Appendix C – Detailed Response to Submissions

Item	Issue Raised	Comment
Department of Planning, Housing and Infrastructure (DPHI)		
Wran Building Materiality		
DPHI1	Provide a clear rationale for the extent of demolition proposed to the Wran building, including any analysis undertaken that considered alternative approaches.	<ul style="list-style-type: none"> The Wran building and adjacent Galleria have been extensively modified since first opening of the museum in 1988. Originally designed as the front door and shop, the Wran Building now houses exhibition spaces following works in 2011-2013, with the museum entrance on the southern façade. The resulting exhibition space does not provide the internal environment suitable for modern museum practice with insufficient light and acoustic separation and intrusion from internal columns and mezzanine offices. The recladding of the Wran façade will improve the environmental and amenity performance of the exhibition space, by particular, improving acoustic and light control. The removal of columns and mezzanines (that are no longer required for office space) will further create the necessary flexible flat floor exhibition space that the mu

3 LEVEL 04
SCALE: 1:500

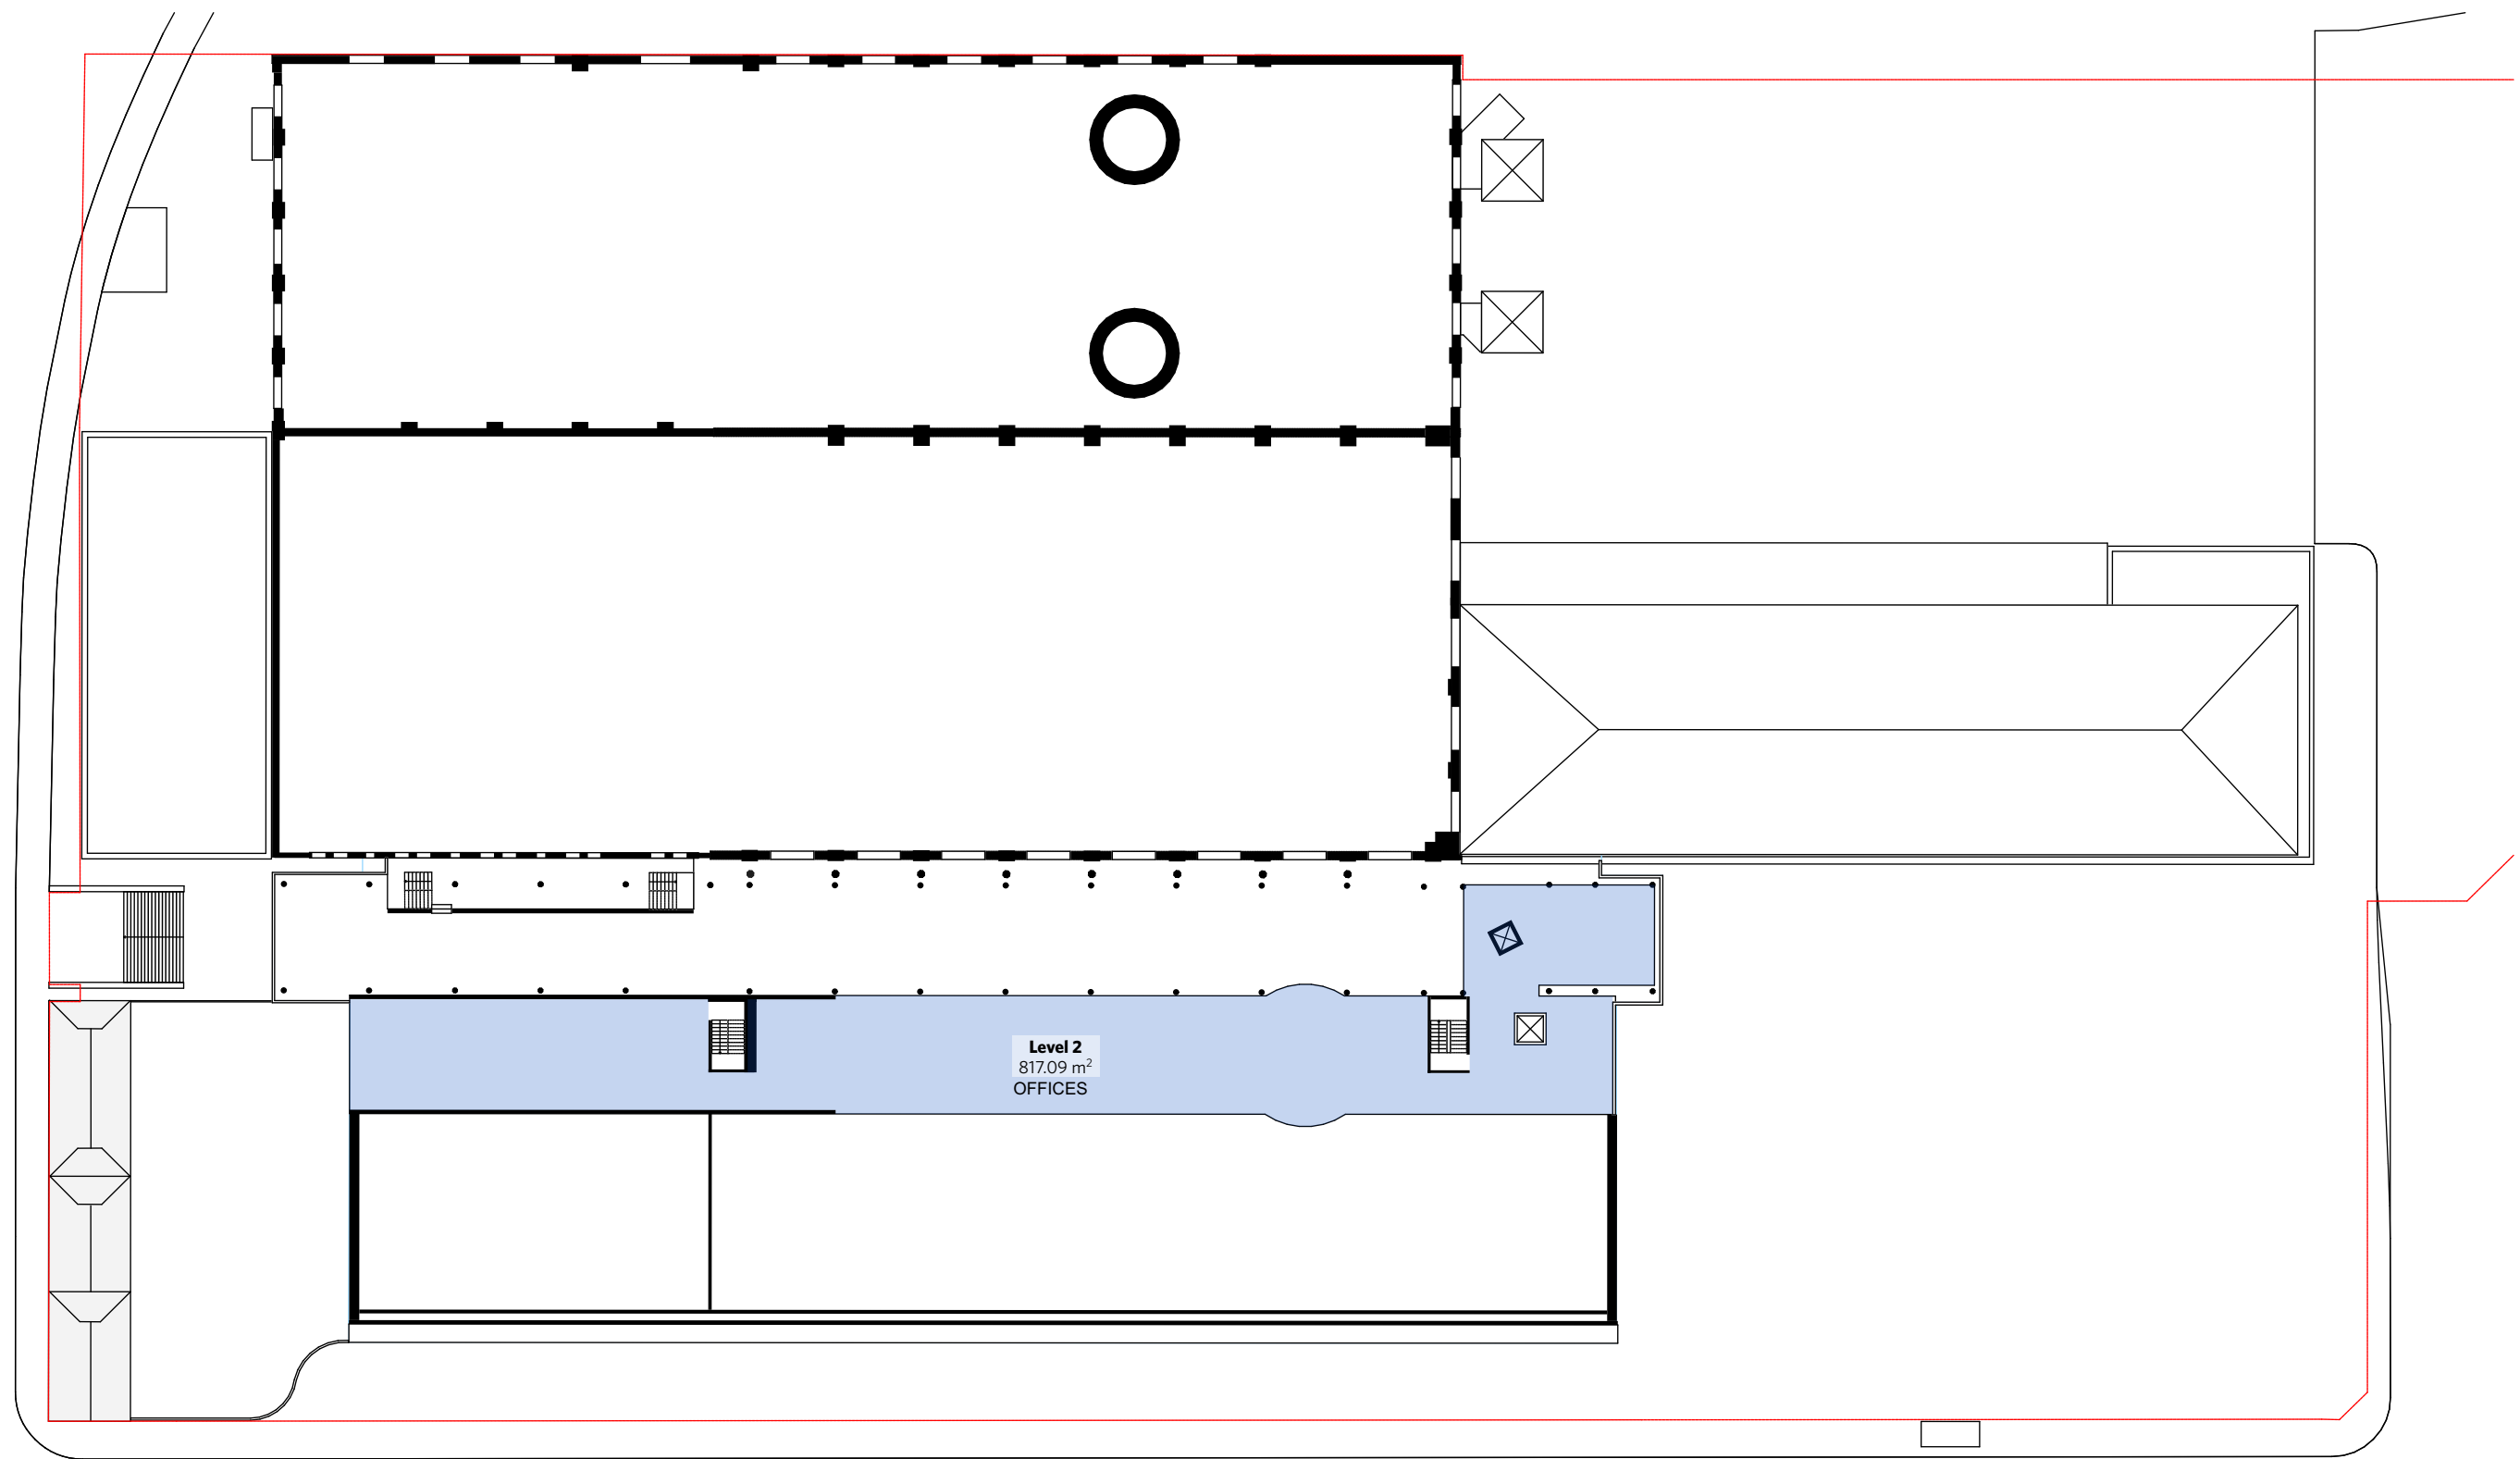
<p>dynamic programs that facilitate direct connections with Powerhouse collections are essential for the museum's future.</p> <p>The revitalisation of Powerhouse Ultimo is occurring within the context of the wider Powerhouse program that includes the recent expansion of Powerhouse Castle Hill) the establishment of Powerhouse Parramatta (under construction) – together these facilities represent a significant expansion of the Powerhouse's museum spaces and overall capacity to deliver programming with increased diversity, reach, and relevance to the community.</p>
CoS3	<p>The City notes a discrepancy between the existing gross floor area (GFA) plans submitted for the original design and the amended design, as well as an overall reduction of 873.15sqm in the amended proposal. Back of house at ground floor appears to be excluded, which is inconsistent with the definition of GFA contained in the Sydney Local Environmental Plan 2012. This discrepancy should be resolved and publicly clarified prior to a determination. The following comments are made in response to the amendments proposed and are provided for your consideration.</p>	<p>DBJ has provided updated GFA plans at Appendix E to provide clarification on the existing compared to the proposed GFA as well as the back of house floor area (refer to A.DA6000).</p> <p>The GFA plans have been updated to reflect a recalculation of GFA in alignment with the GFA definition under the Sydney LEP. These plans have clarified areas where the use was previously ambiguous, and it was unclear whether these spaces would be consistent with the GFA definition (such as back of house versus plant room). The purpose of the plans is to clarify the use of these spaces and demonstrate how the GFA has been calculated.</p>

DPHI3	Consider opportunities for additional canopy tree planting in the Gathering Terrace to further improve tree canopy cover across the site.	The Gathering Terrace serves as the primary access point for transport of very large objects directly into the Turbine Hall. The proposed tree planting in the Gathering Terrace maximises the available area for tree planting without inhibiting the ability to load and unload objects into the museum spaces. For this reason, additional canopy tree planting is not able to be accommodated in the Gathering Terrace.
Other		
DPHI4	Clarify the proposed gross floor area (GFA) in accordance with the definition of GFA specified in the City of Sydney Local Environmental Plan 2012.	<p>DBJ has provided detailed GFA plans at Appendix E. The plans provide detailed area plan calculations in accordance with the definition of GFA as specified in the City of Sydney LEP 2012. Existing GFA plans are provided as well as the proposed GFA plans.</p> <p>In summary, the existing GFA of the Powerhouse is 23,002.31m² and the proposed GFA is 51, 257.99m².</p>
